CITY OF ALBUQUERQUE
PLANNING DEPARTMENT
DEVELOPMENT REVIEW BOARD

Project# 1010332

DATE: April 21, 2015
TO: Jack Cloud, DRB Chair
FROM: Catalina Lehner, Senior Planner *CLL*
RE: Project #1010332, SW Subdivision
Site Development Plan for Subdivision with Design Standards

DRB Project Number: 1010332
Los Diamantes

Drawing file: Old Prelim Plat / Grading Plan.pdf

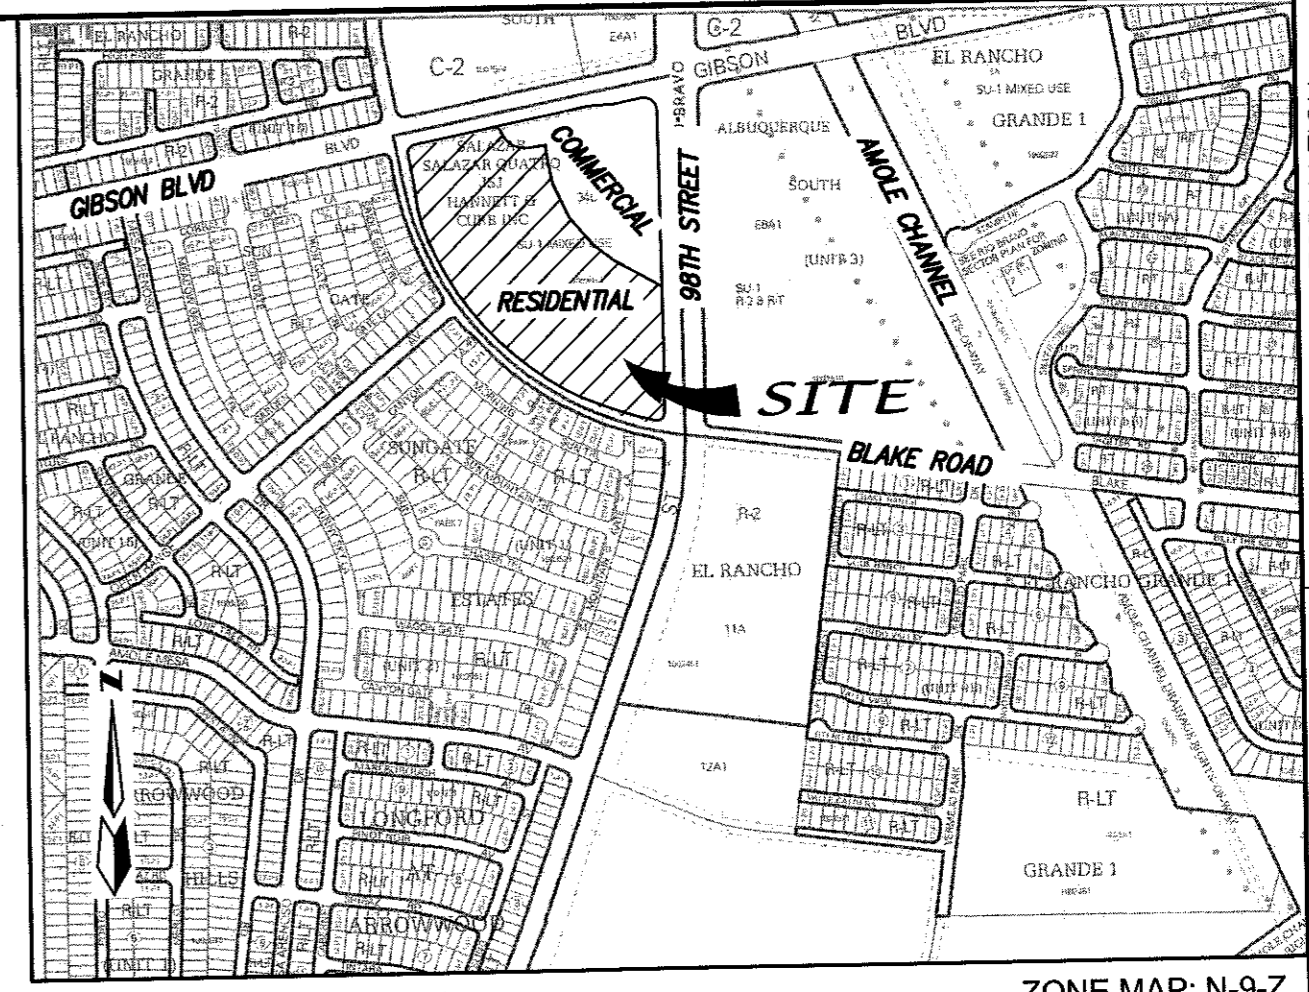
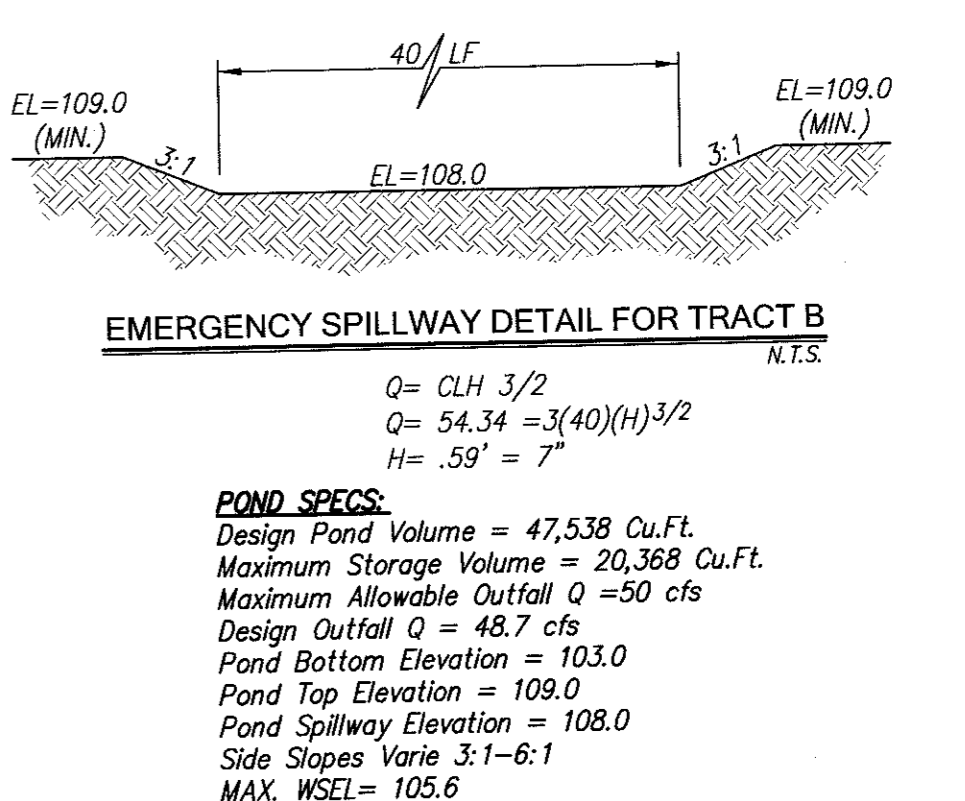
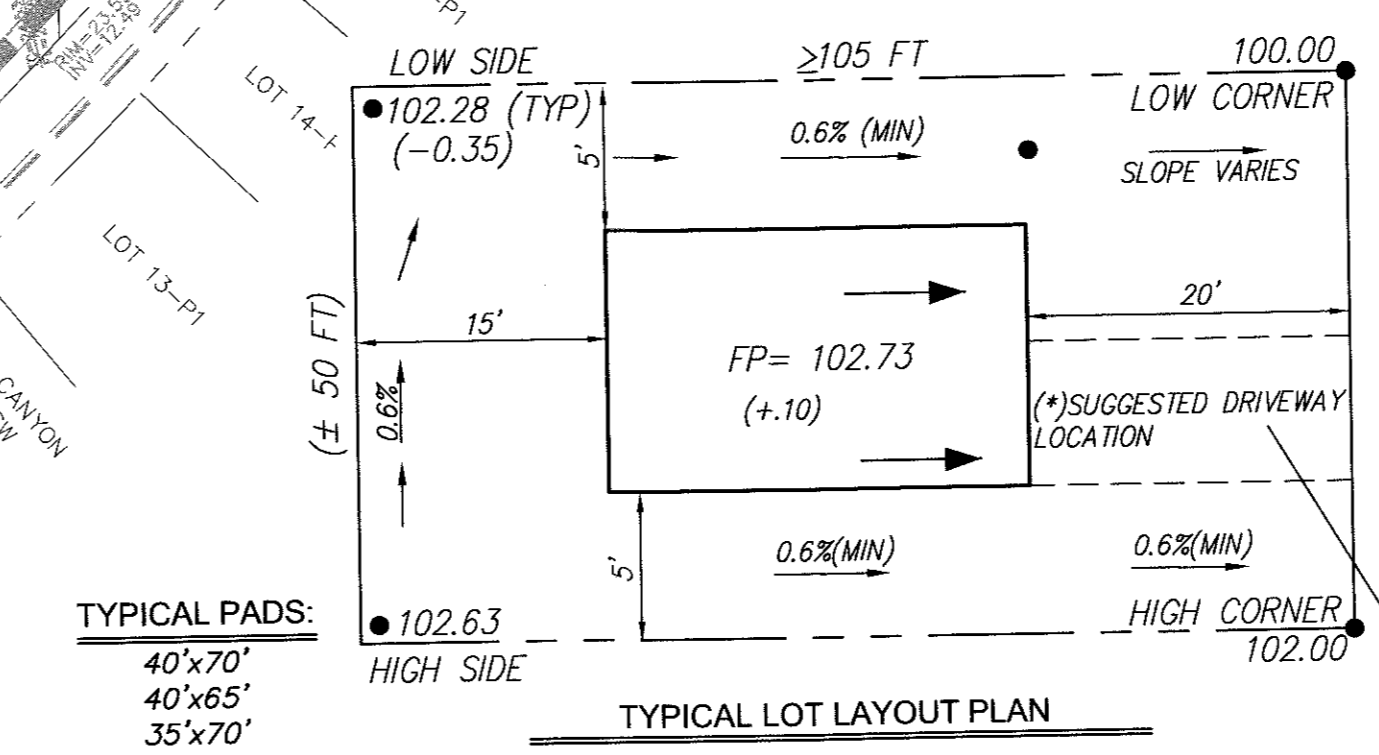
Four changes were made from v.3, which the EPC approved and appear to be unauthorized.

- The perimeter/retaining wall section is different on v. 4 and needs to be re-instated to match that on v.3.
- The Los Diamantes Drainage Plan drainage narrative was approved by the EPC and needs to be re-instated.
- The Outfall Detail now shows a 10.5' opening (was 8.6') and the first flush retention volume as 104.38 (was 106.42).
- An Emergency Spillway detail was added.

**LOS DIAMANTES SUBDIVISION  
SITE DEVELOPMENT PLAN  
FOR SUBDIVISION  
COMMERCIAL DESIGN STANDARDS**

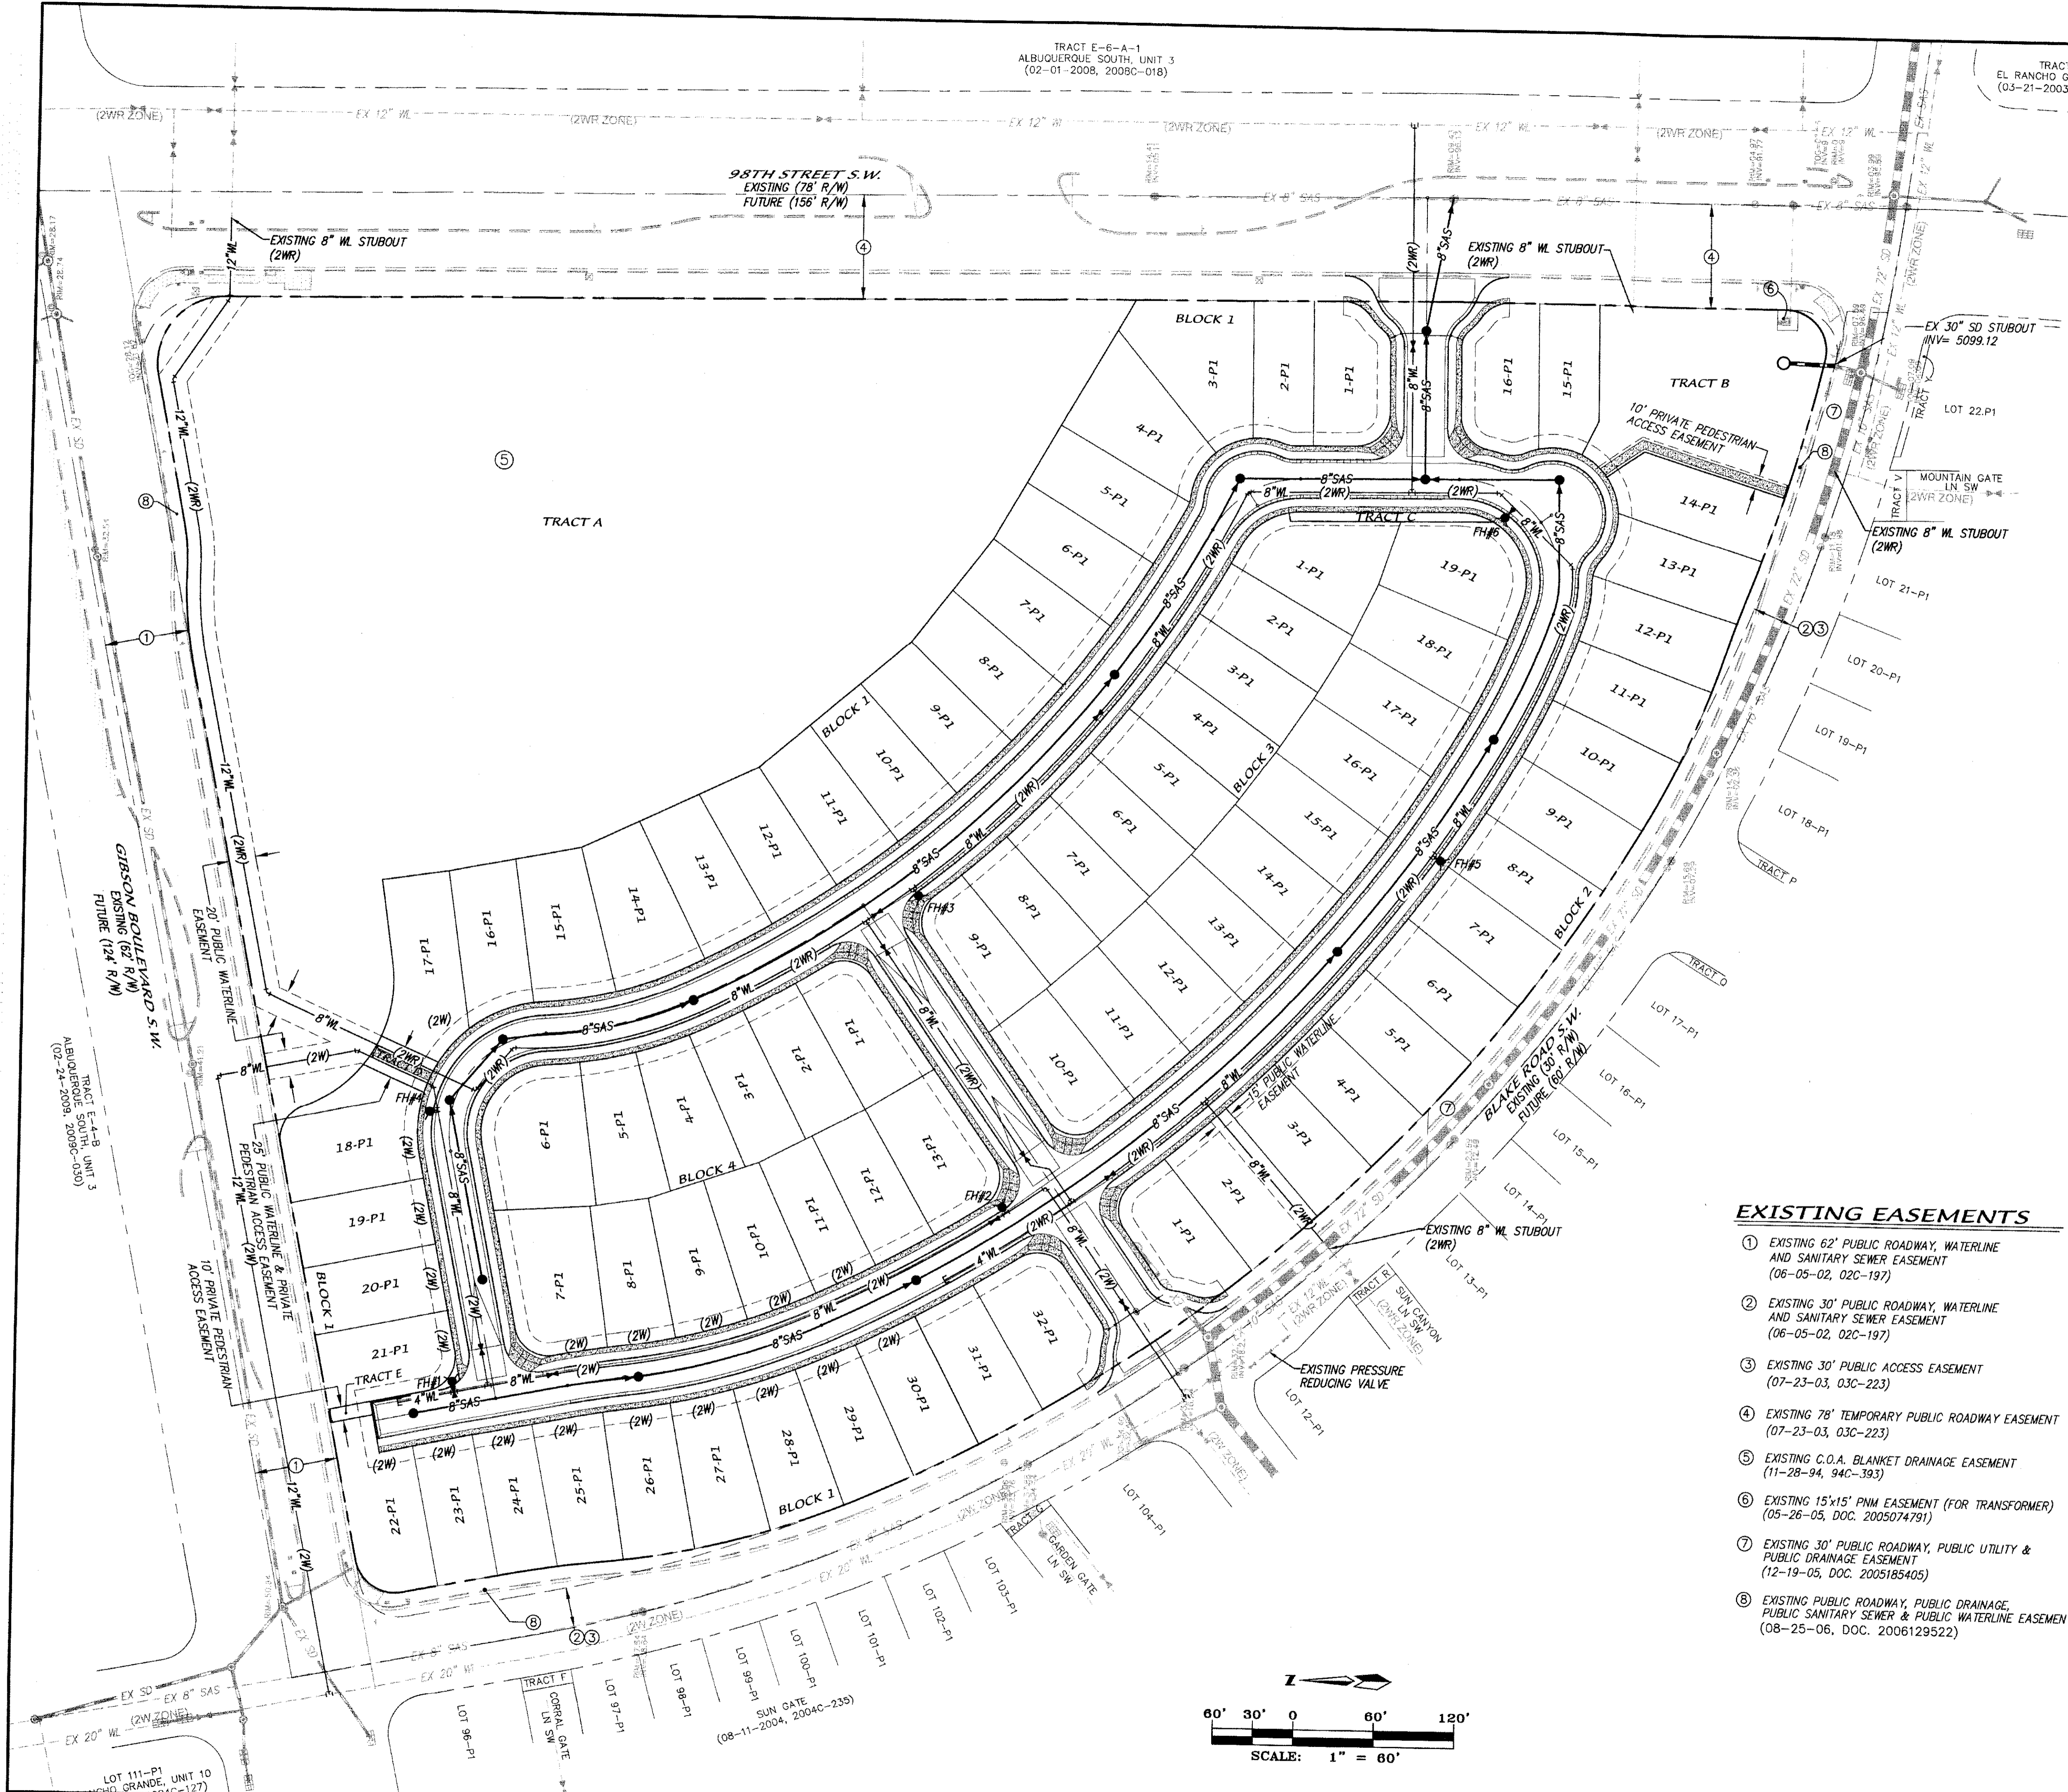
Condition 7A: Please re-phrase standard H: "Bicycle access and pathways shall be accumulated and provided." I'm not sure what accumulated means here. Maybe just use "provided."

Condition 13: Instead of adding a new section X. Utilities, the two PNM comments C and C, pertaining to utilities, should be added to the existing VIII. Utility Standards, as new standards H and I.
